Your Ref: OWPC25330
Our Ref: WA/7/19/RES
Please ask for:
Mr A Wood

Approval of reserved matters following outline consent WA/26/18/OUT for layout & scale for 6 No. dwellings & 6 No. detached garages.
Lanes End West Walberton Lane Walberton

PJ DEVELOPMENTS LTD 2 Square Chambers 23 High Street Emsworth PO10 7AQ Tel: 0843 289 3430 Email: enquiries@pjdevelopmentsltd.com	
PROJECT: FORMER LANES END	
SITE PLAN OUTLINE PLANNING APPLICATION	
DATE: JANUARY 2019	DWG. NO 19-001 PL02
SCALE @ A1: 1:200	
REV: C

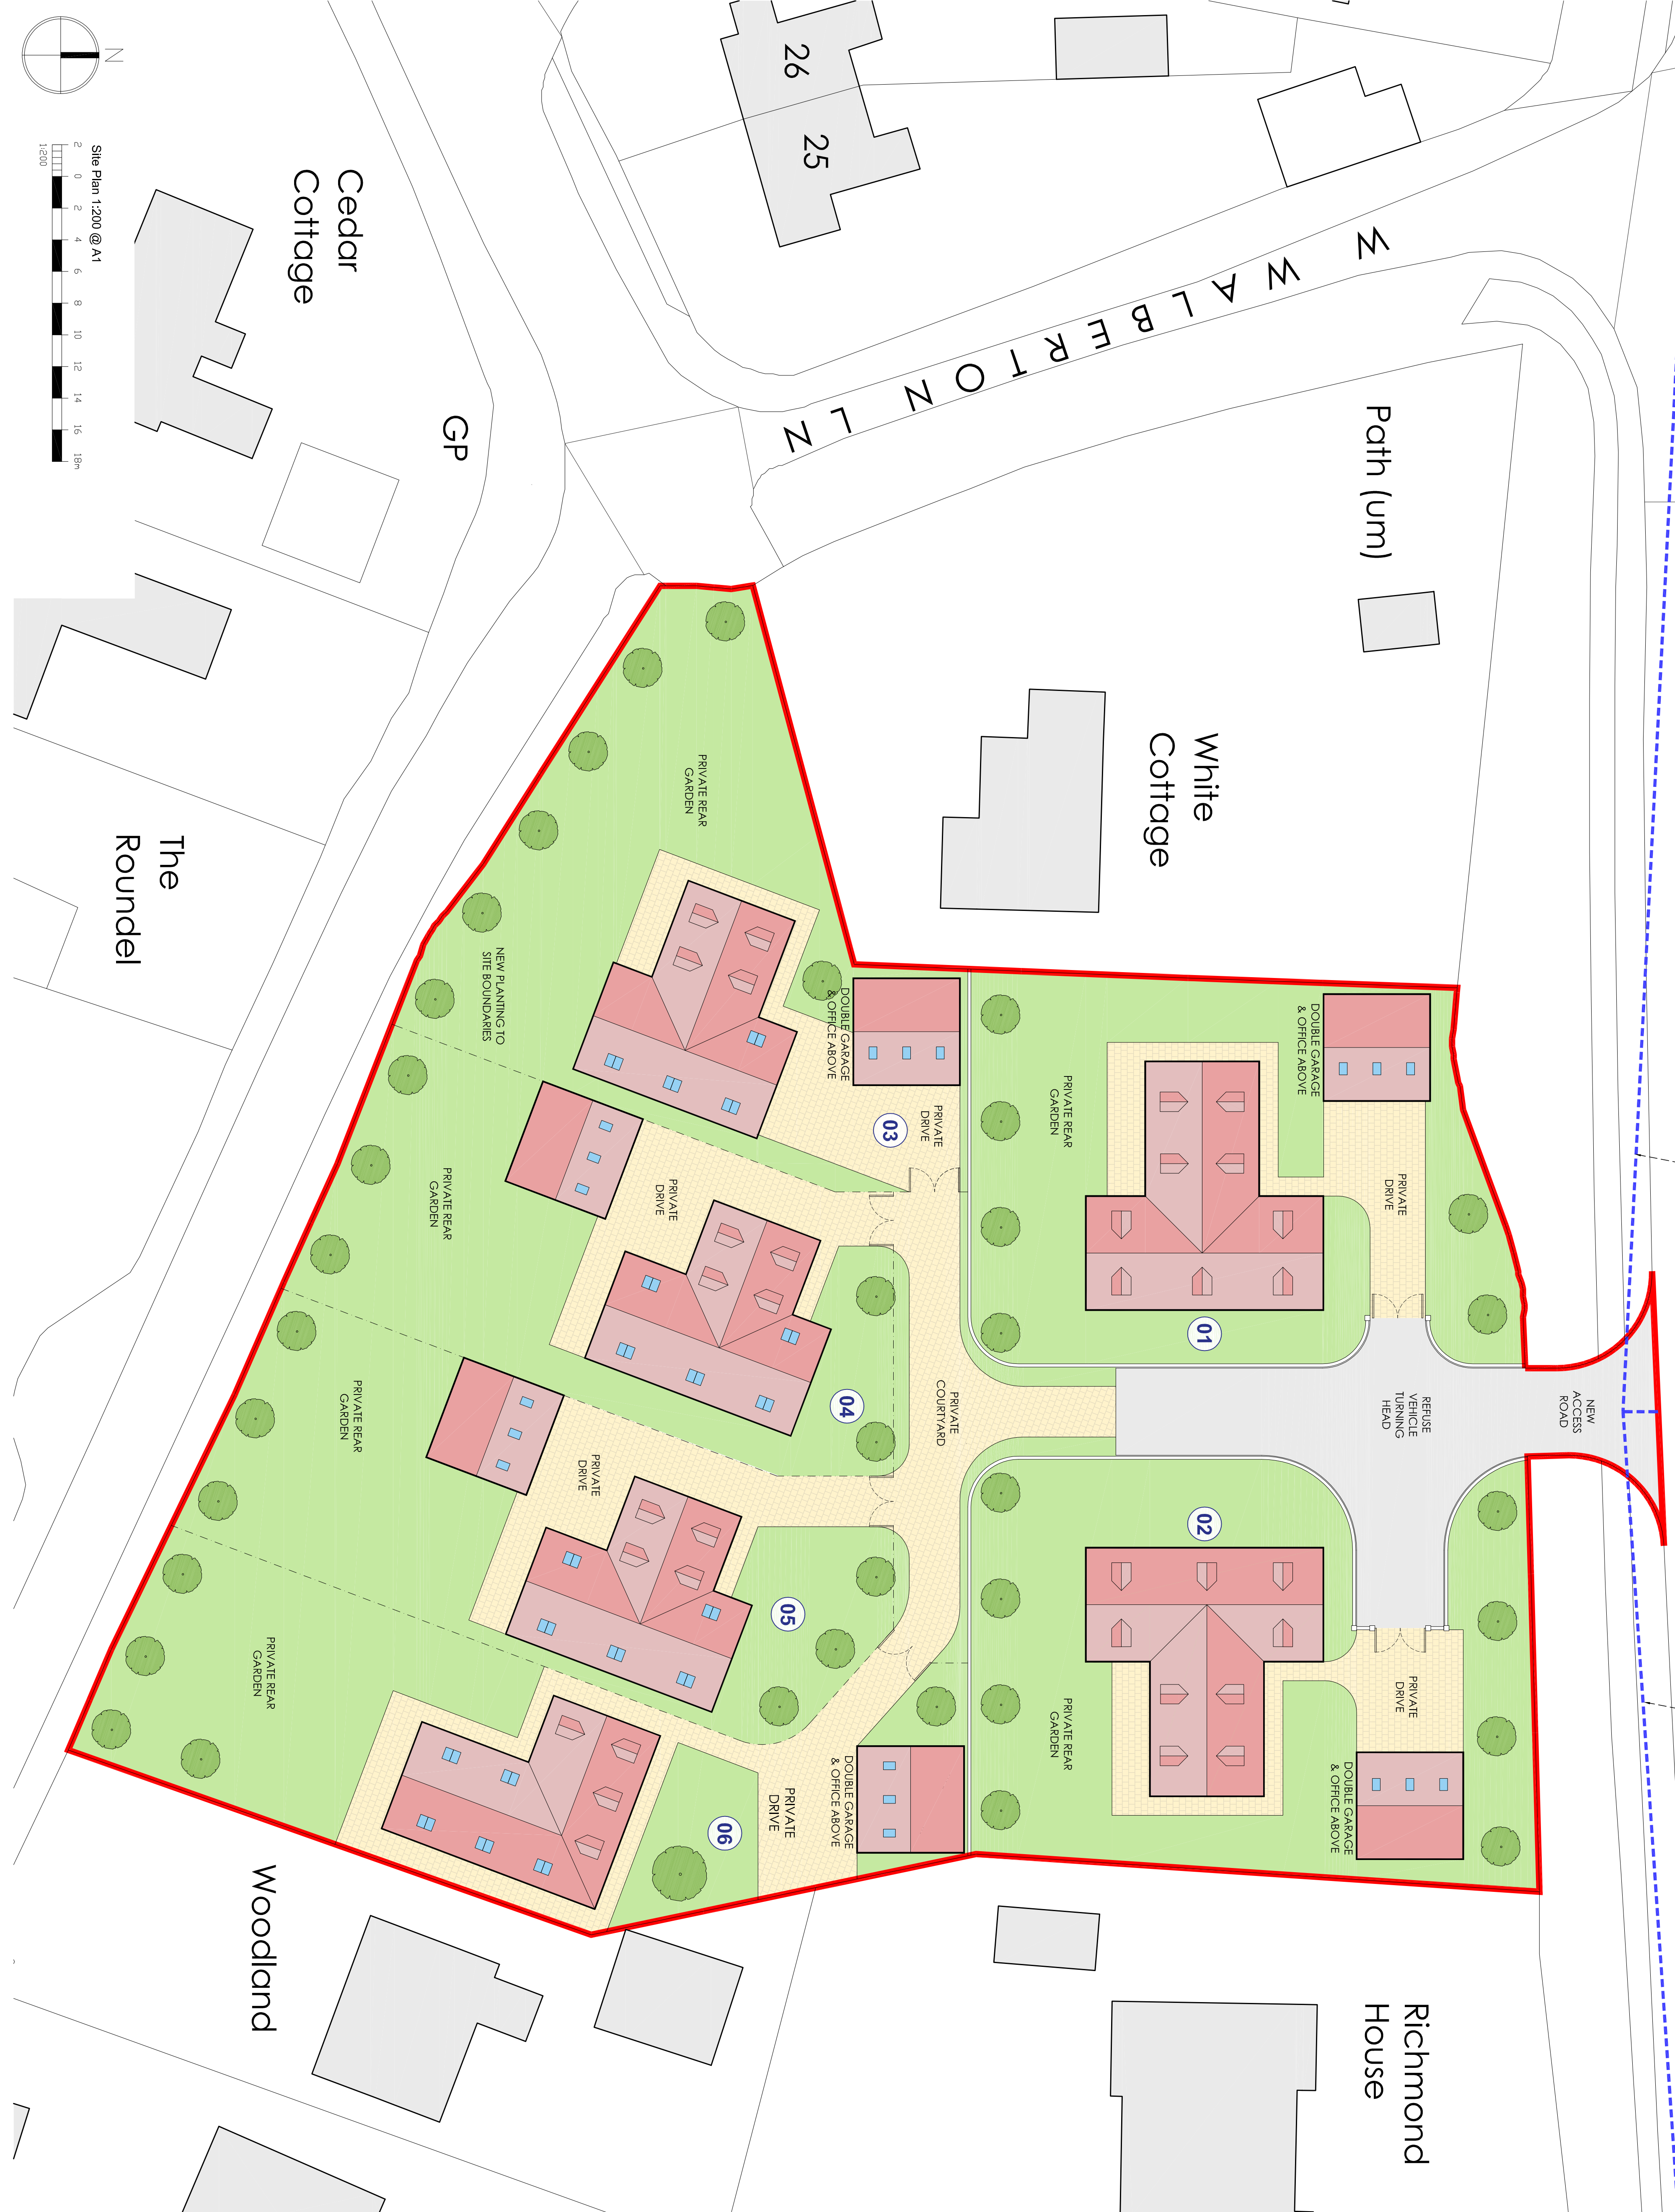
There is a response from WSCC on 22/11 regarding Waste Collection that the waste authority should provide comments and they said that ideally swept path tracking should be demonstrated. Please consider this as we remain concerned about the density of this development.

PLOTS 1 AND 2 FLOOR PLANS AND ELEVATIONS

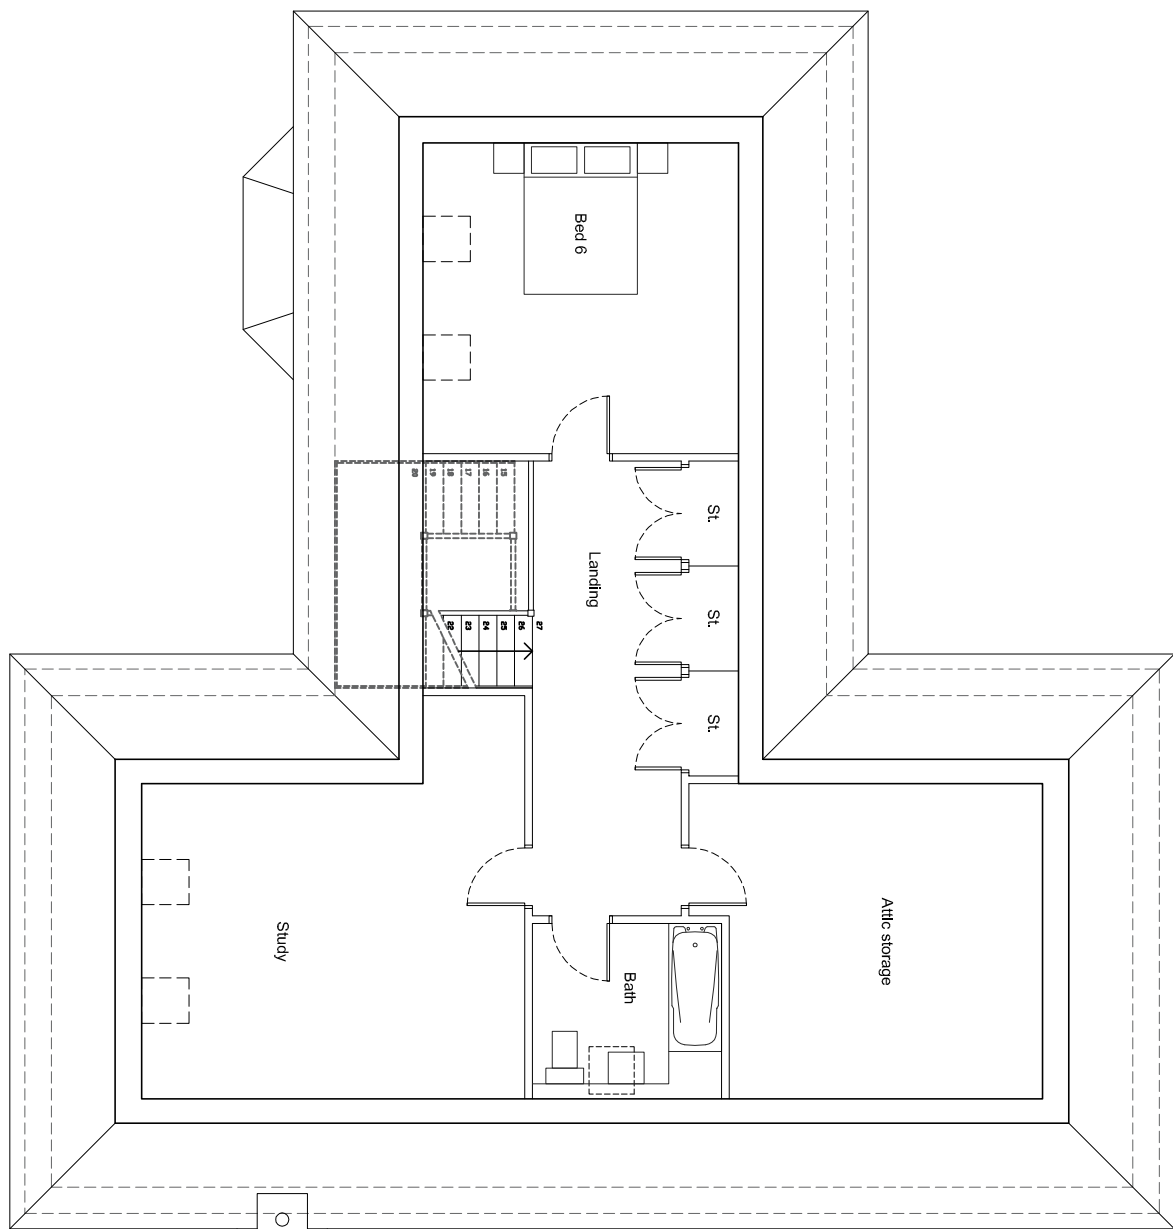
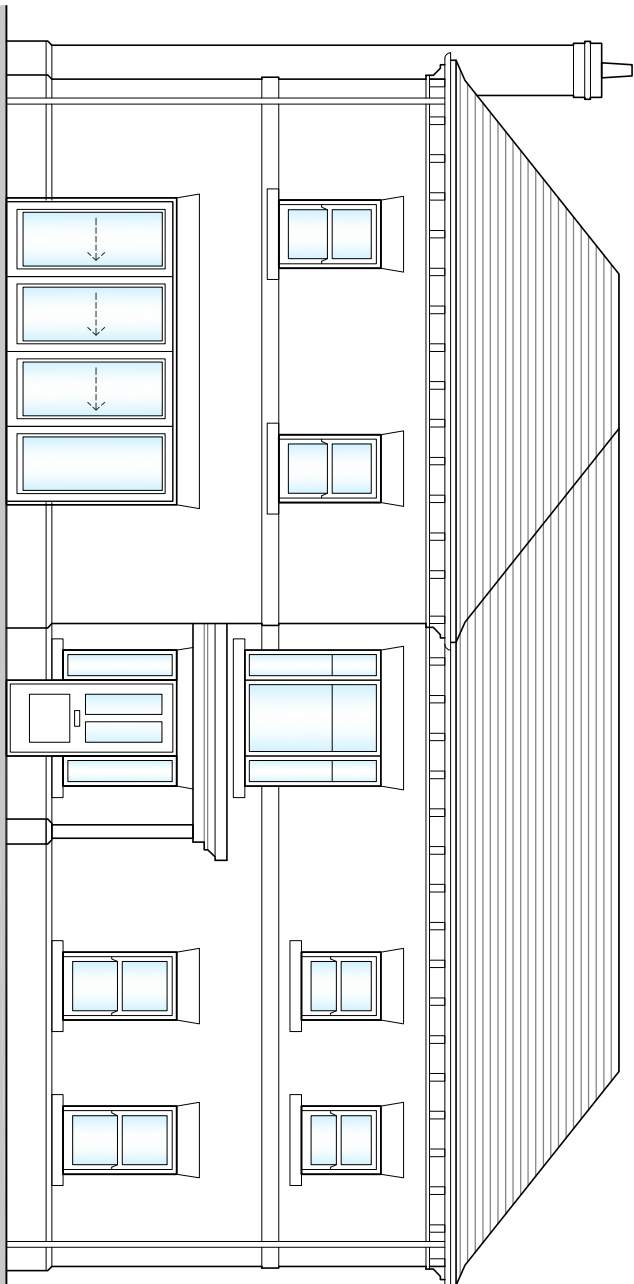
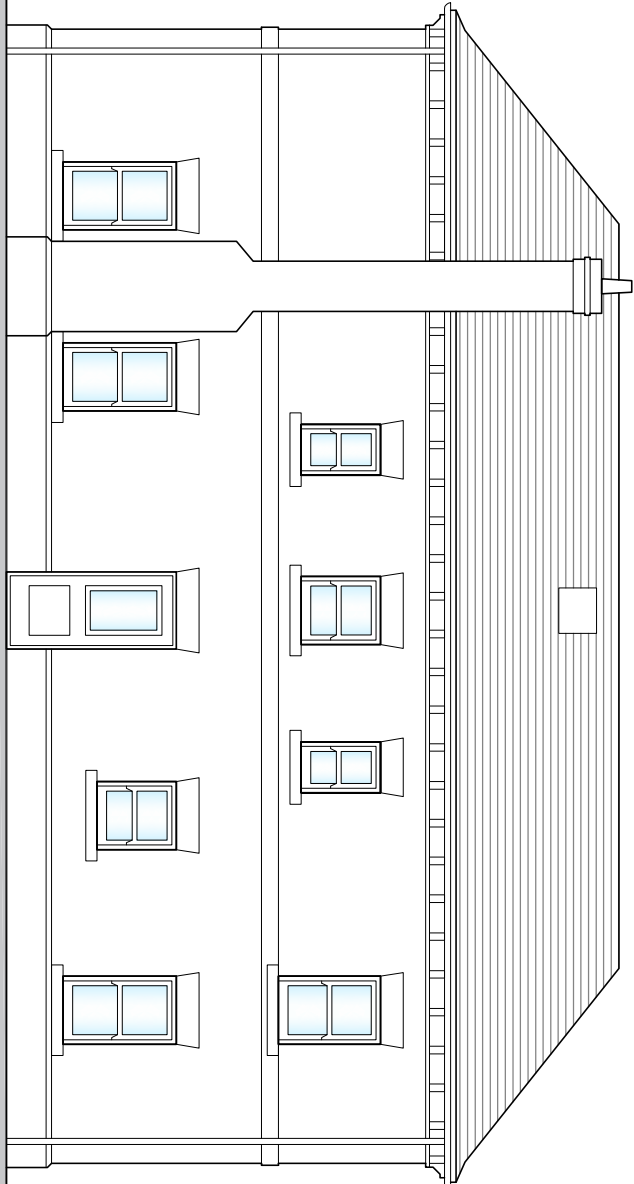
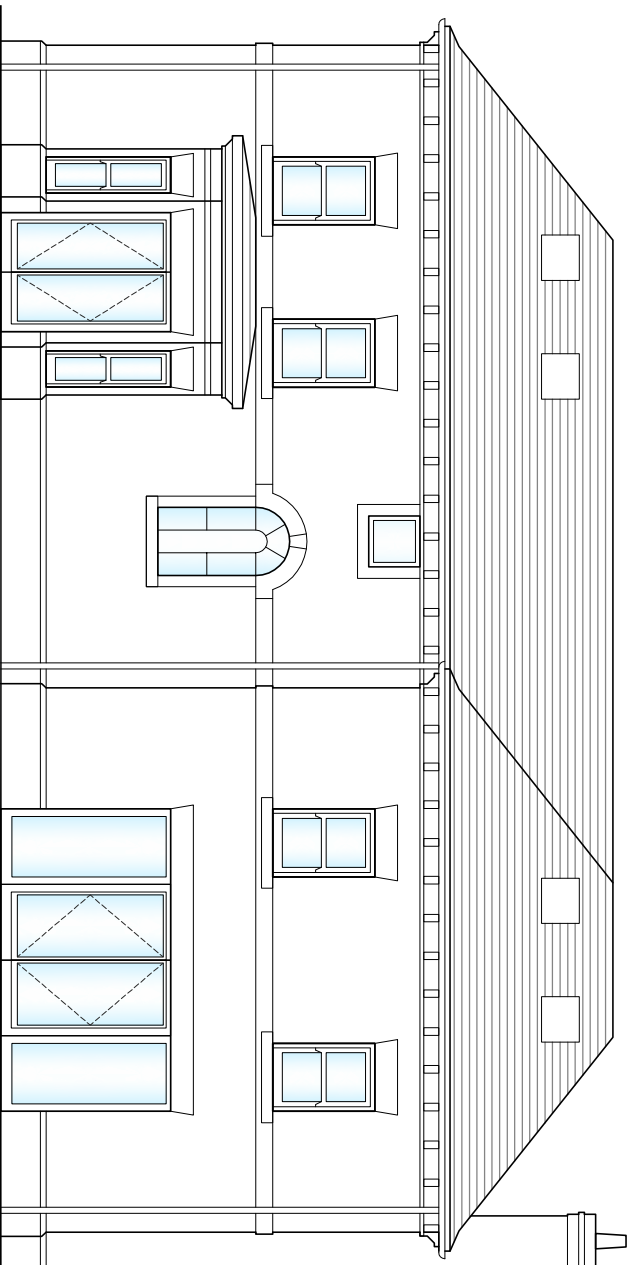
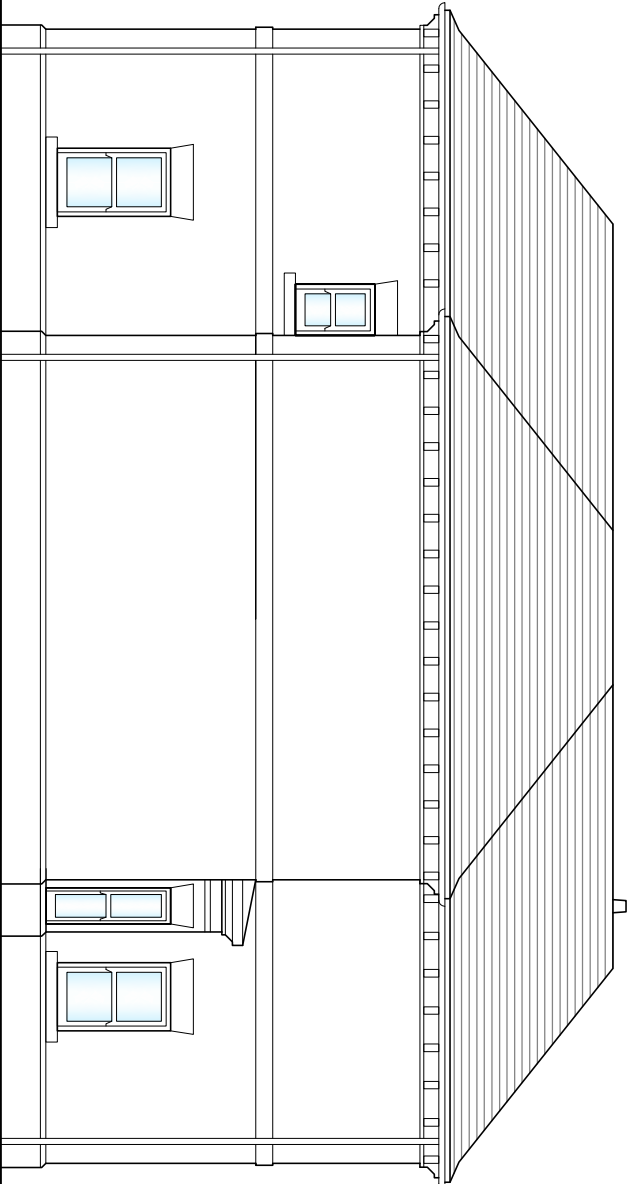
Arun previously said no to 3 stories and originally said no to any rooms in the loft. However, the response from the developer confirms 2.5 story. We still consider this out of keeping for the area and therefore inappropriate.
